Rezoning Transportation Analysis

Petition Number: 2021-193

General Location Identifier: 20120110

GRAHAM PARK INDUSTRIAL
 REZONING PETITION NUMBER 2021-193
 CHARLOTTE, NORTH CAROLINA
 GRAHAM PARK, LLC
DEVELOPMENT STANDARDS

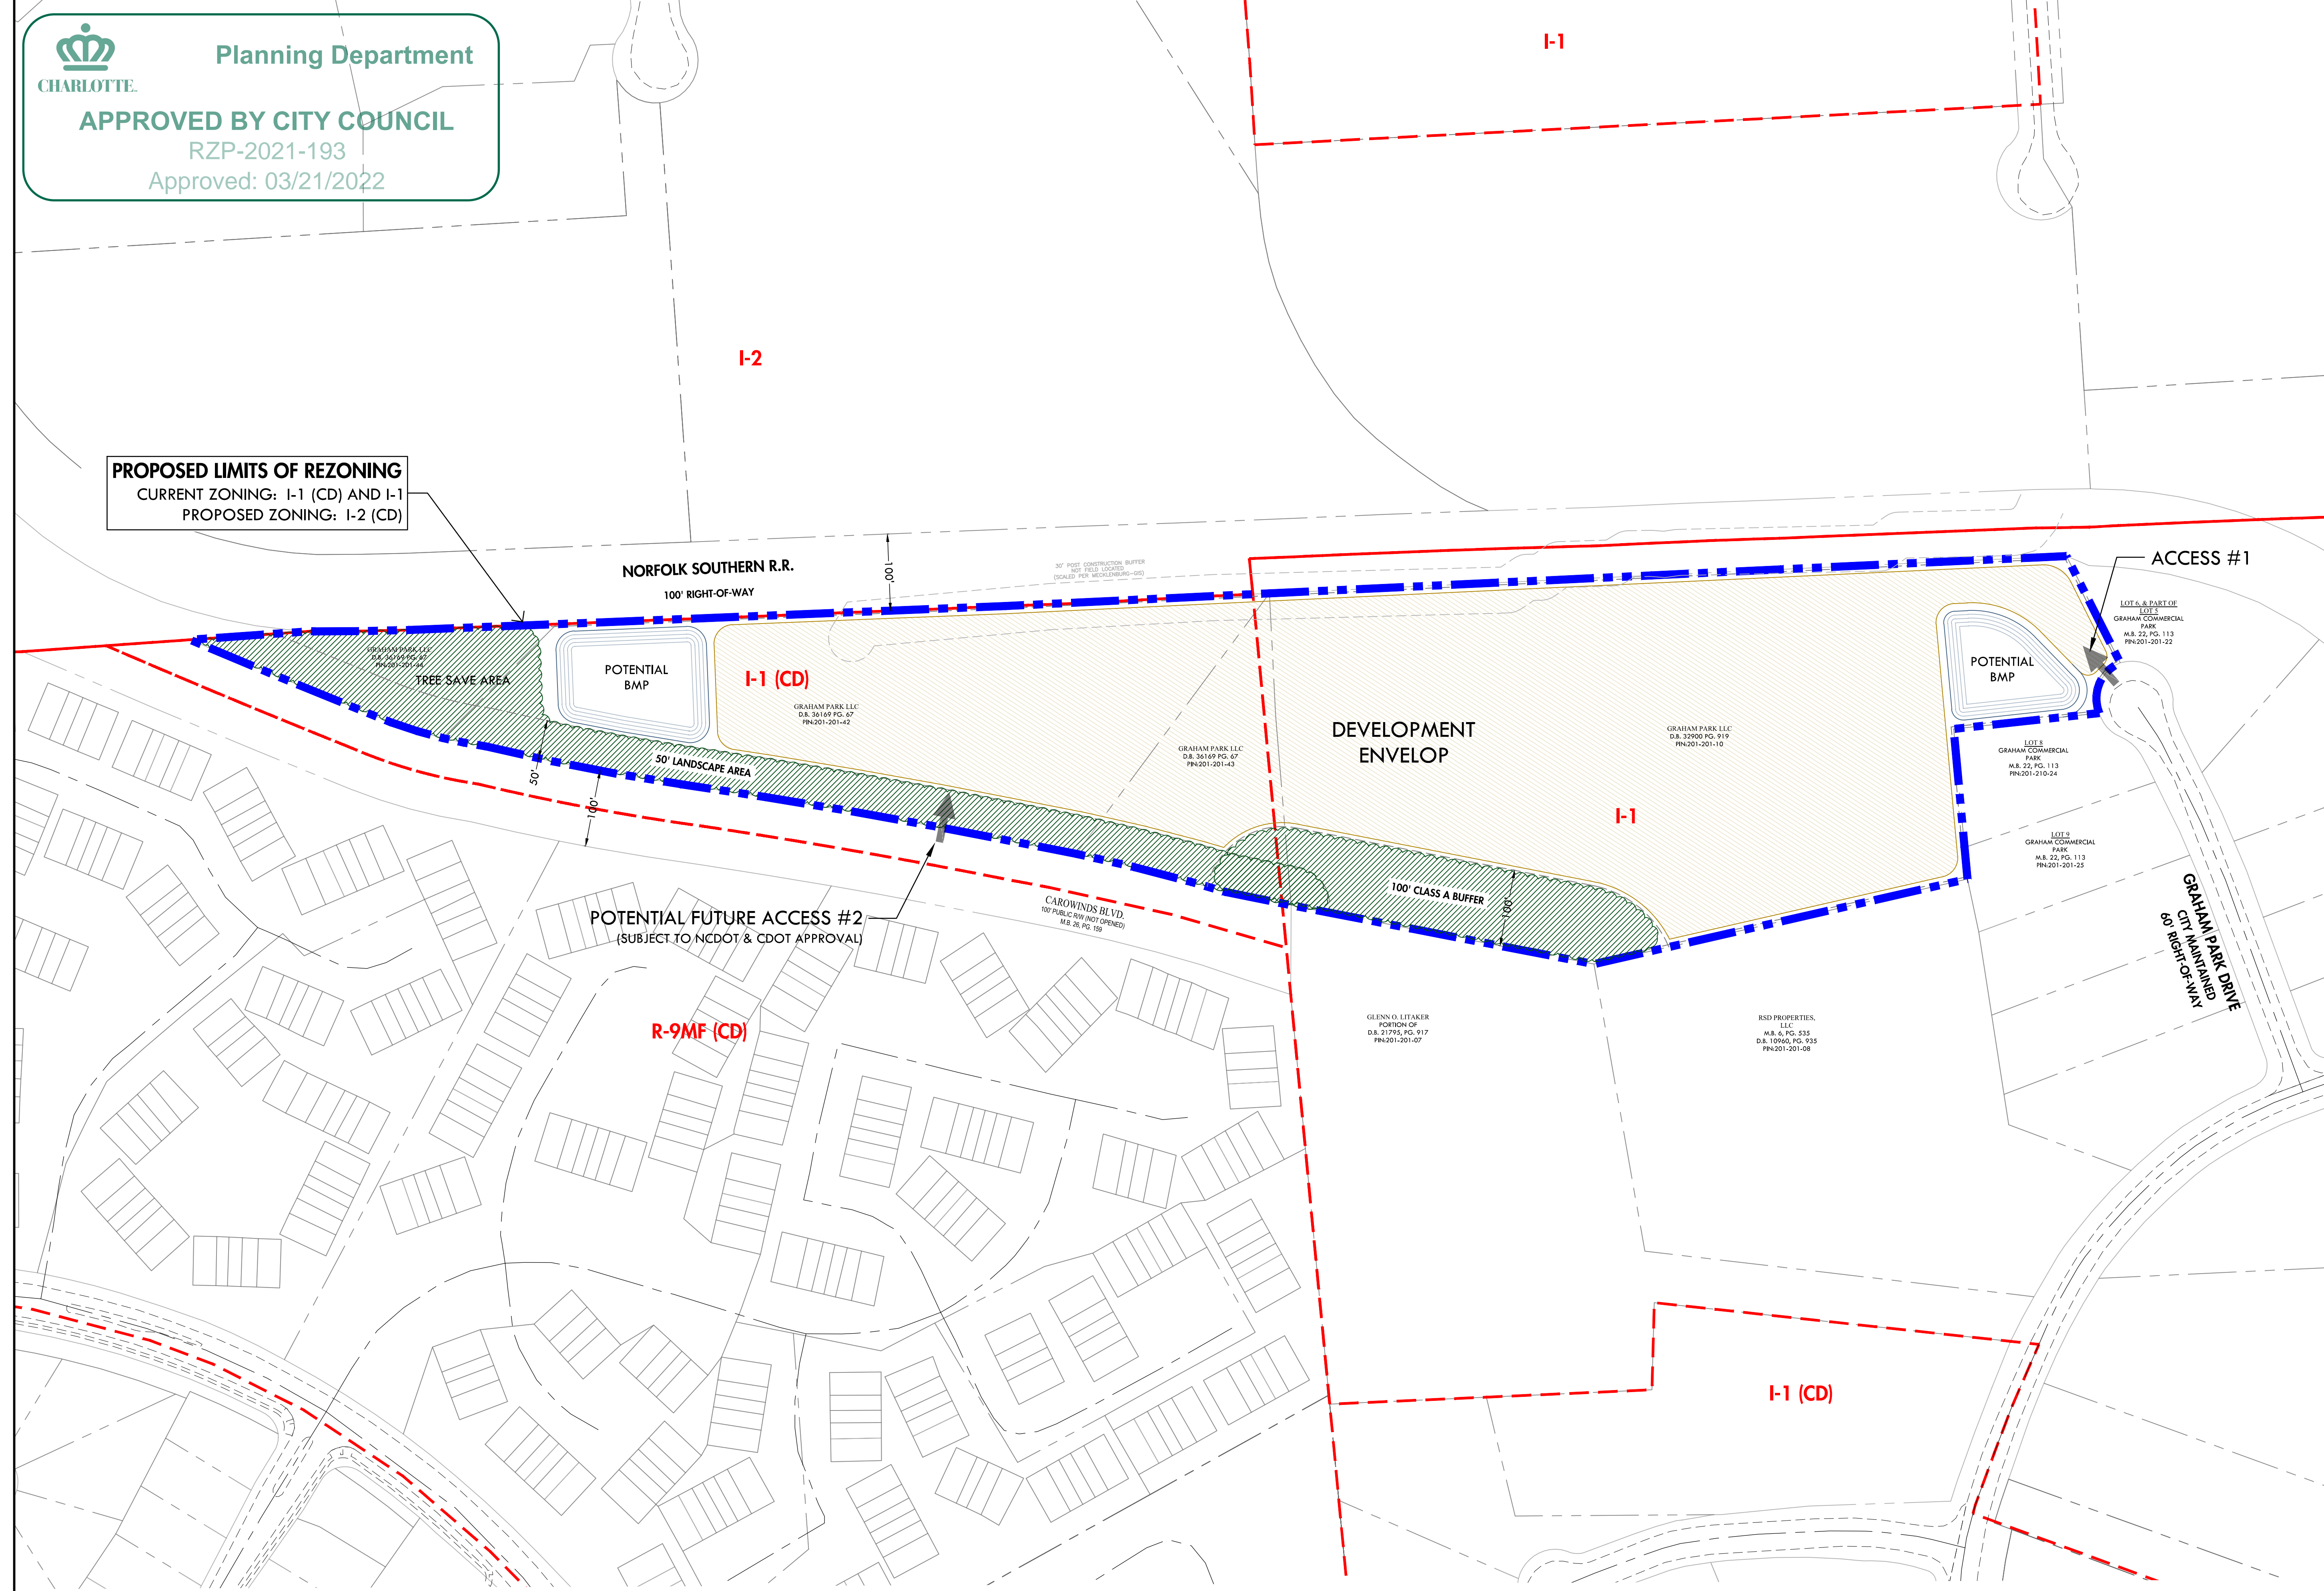
2. ~~Revise conditional note 4.C to:~~

~~“At such time as NCDOT STIP# U-6168 (Carowinds Boulevard Extension) is constructed, the petitioner may coordinate with NCDOT and CDOT to construct a single driveway connection, as means for secondary site access. This driveway will be subject to NCDOT and CDOT approval.”~~

Update to Comment as a result of 01-17-2022 Site Plan: ~~Revise conditional note 4.C to the following:~~

~~“At such time as NCDOT STIP# U-6168 (Carowinds Boulevard Extension) is constructed, the petitioner may coordinate with NCDOT and CDOT to construct a single driveway connection, as means for secondary site access. This driveway will be subject to NCDOT and CDOT approval.”~~

C. AT SUCH TIME AS NCDOT STIP# U-6168 (CAROWINDS BLVD EXTENSION) IS CONSTRUCTED, THE PETITIONER MAY COORDINATE WITH NCDOT AND CDOT TO CONSTRUCT A SINGLE DRIVEWAY CONNECTION, AS MEANS FOR SECONDARY SITE ACCESS. THIS WOULD INCLUDE THE OPTION FOR A FULL ACCESS DRIVEWAY THAT WILL BE SUBJECT TO NCDOT AND CDOT APPROVAL.
